Your Ref :
Our Ref : LU/228/17/NMA

Application for a Non-Material Amendment following a grant of planning permission LU/205/16/PL relating to buildings set at 1010mm from boundary & repositioned, extended amenity space, relocation of entrance to flat, changes to windows, internal alterations, changes to balcony support & change in windows & door materials to UPVc
C M Wood Body Repair Centre, Linden Park, Littlehampton,

GROUND FLOOR PLANS
1:100

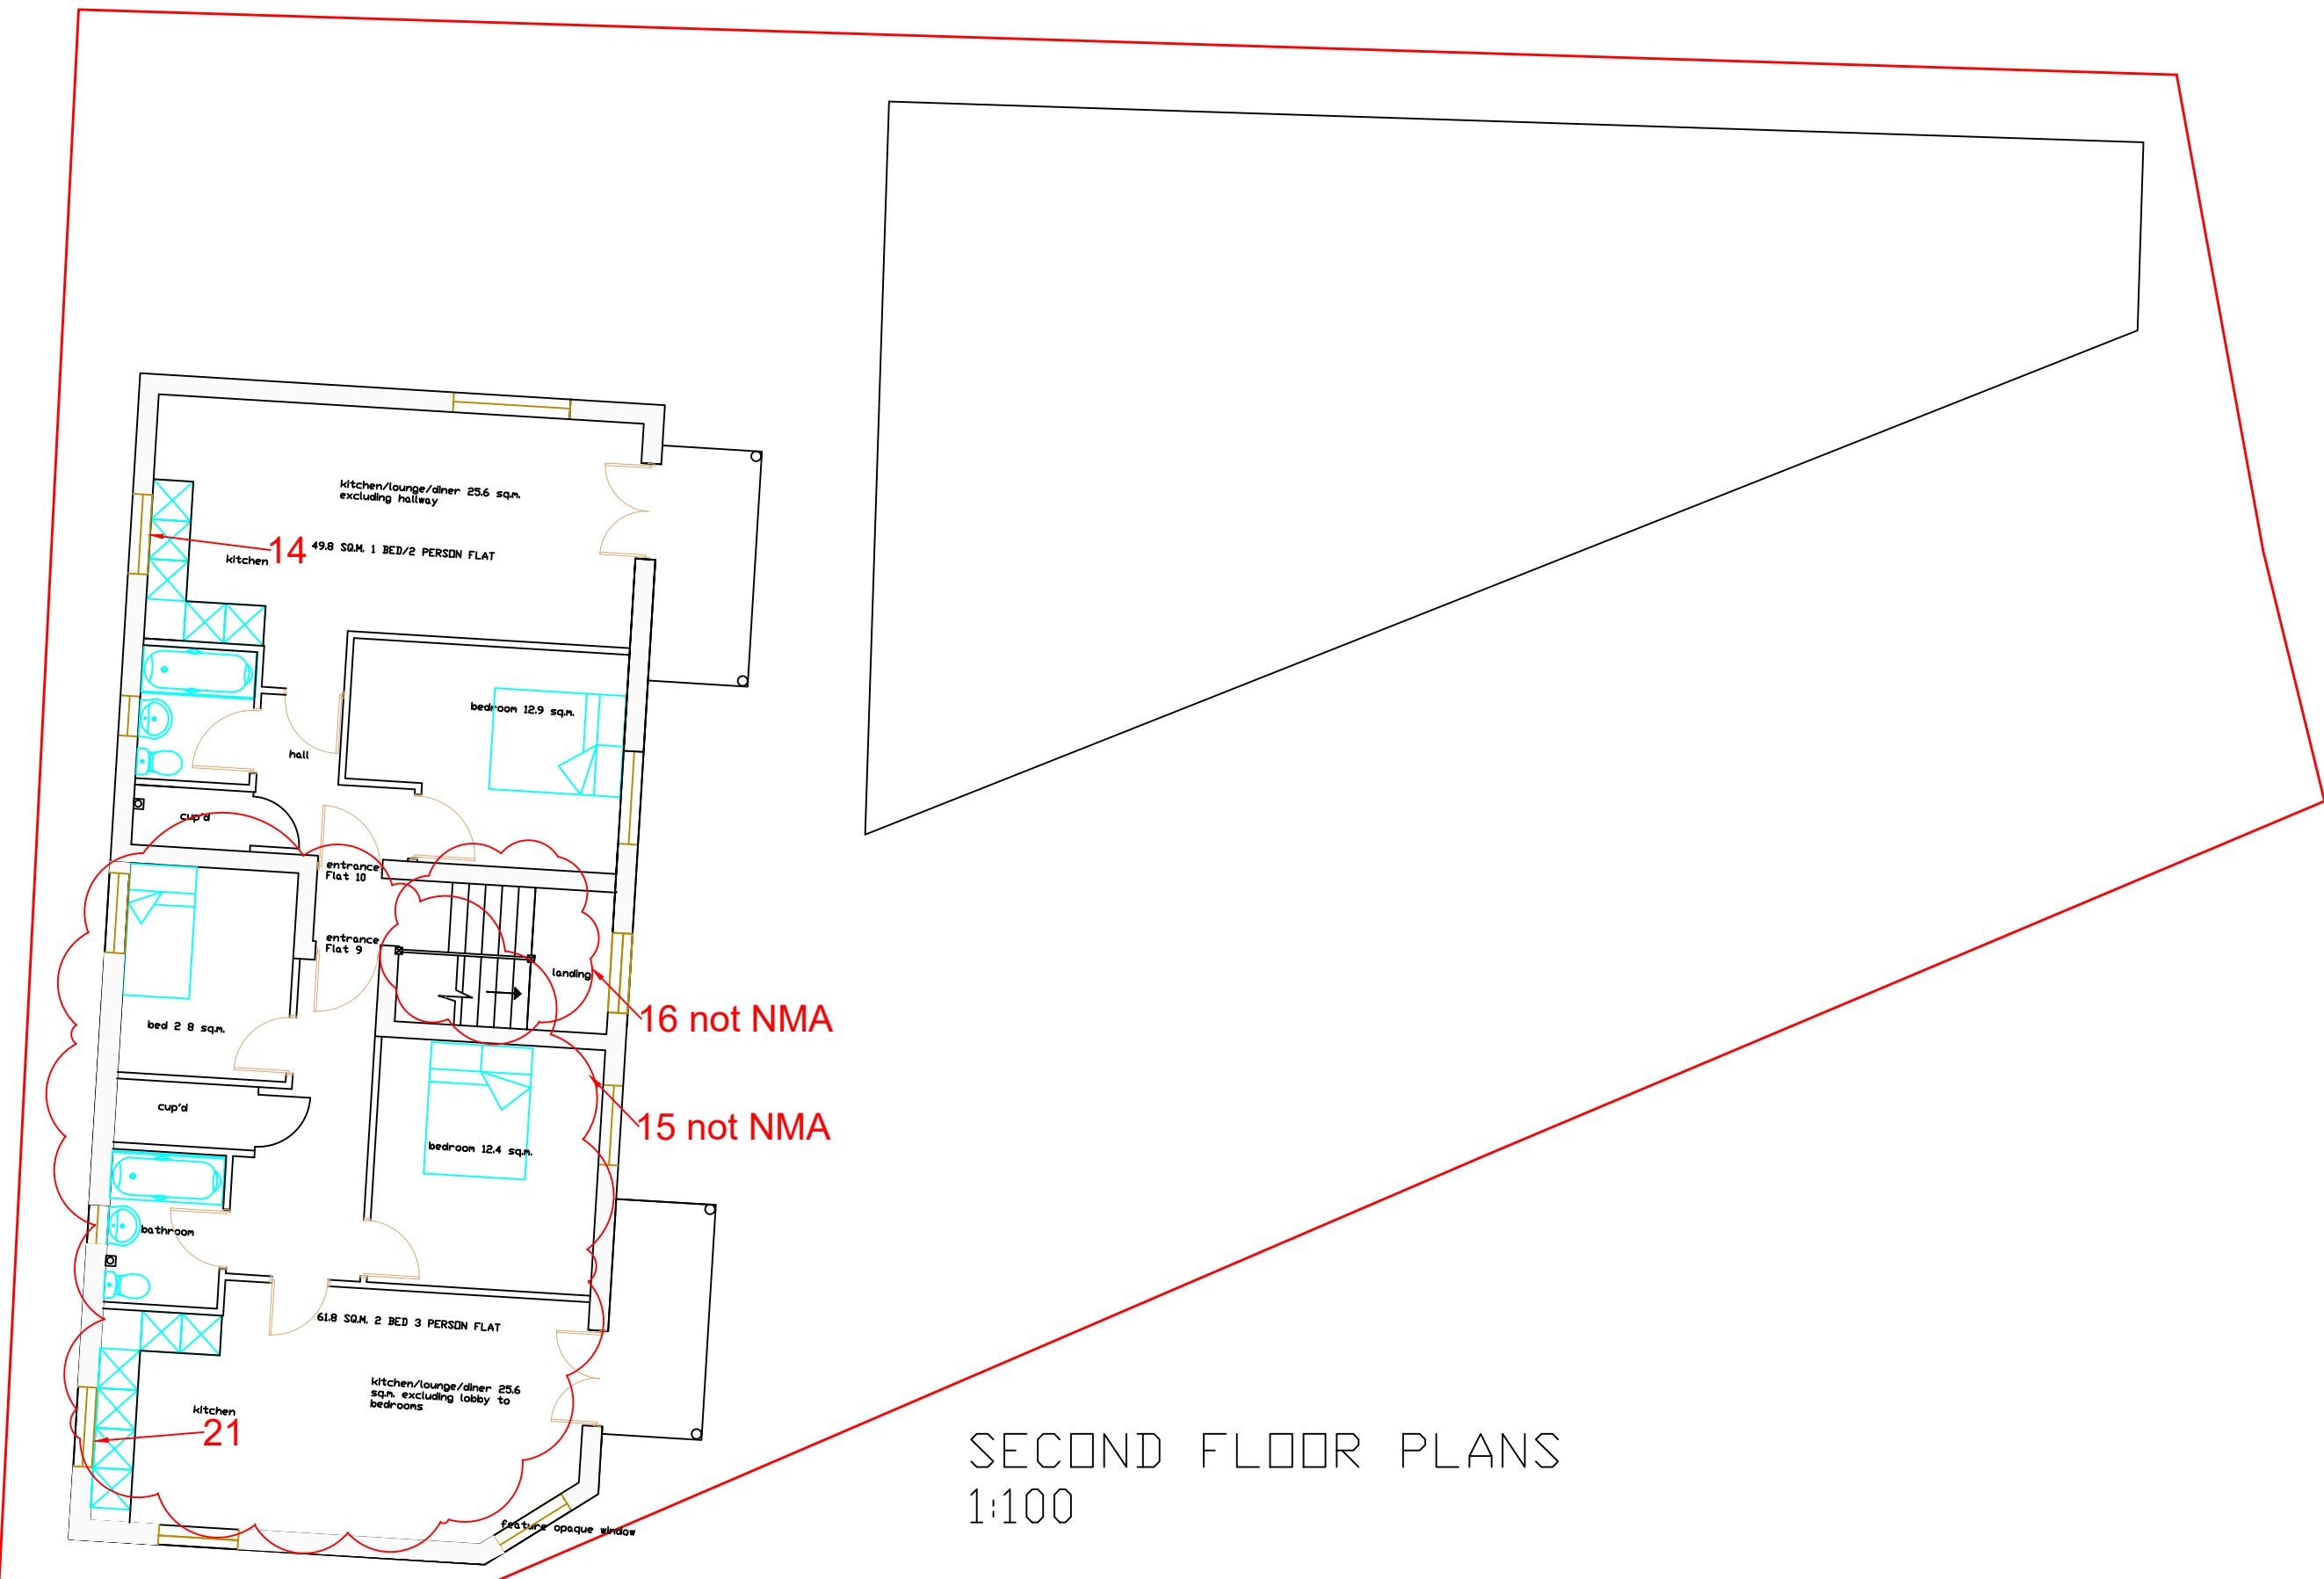
- Buildings moved further from site boundaries and re-aligned slightly to provide a gap to the boundaries of 1010mm from the boundary
 - Footpath moved and amenity space width reduced slightly to accommodate for moving building forward.

- Flat 1 - Amenity space extended to in front of window
 - Flat 2 - Amenity space extended and gate added for access
 - Flat 1 - Entrance to Flat 1 relocated to inside main entrance to facilitate improvements to internal layout. Original front door in South elevation removed.

- Flat 1 - High level window now in West elevation. Normal cill window in South elevation`
 - Flat 3 - High level window now in West elevation. Normal cill window in South elevation`

- Flat 4 - Kitchen window smaller (800 instead of 1200) and moved
 - Flat 2 - Internal entrance blocked off. Entrance now from East elevation and double doors changed to single door with full height side light

- Flat 5 - Window to bedroom 2 moved 250mm
 - Flats 6, 8, 10 - Window to kitchen area (far West) moved inward to East by 600mm
 - Balconies throughout. Added vertical supports to all outward corners.

- Block 1 (3 storey) Stairwell. FF landing window on ½ landing deleted.
 - Block 1 FF landing window to South elevation made bigger to match 2nd floor bedroom window

- Flat 5 Bedroom 1 - Small window deleted due to new internal layout
 - New windows to South elevation to Block 1, flats 5, 7, 9. New windows positioned in kitchen.

- Retained walls now shown on Site Plan to North boundary. Originally the walls were to be removed and replaced with fencing. It is now proposed to retain the flint wall to this boundary as well as part of the building wall which is attached to it. It is felt this adds to the security of the site.

- Communal Amenity Space to put bin store more accessible to residents and collection operatives.
 - All windows and doors to be UPVc. The Application stated grey Aluminium

- Accordingly drawings 15160/01 r2 Proposed Site Plan, 15160/07r2 Site showing Boundary Treatments and Indicative Landscaping and 15160/04r1 Proposed Elevations have become the approved plans.
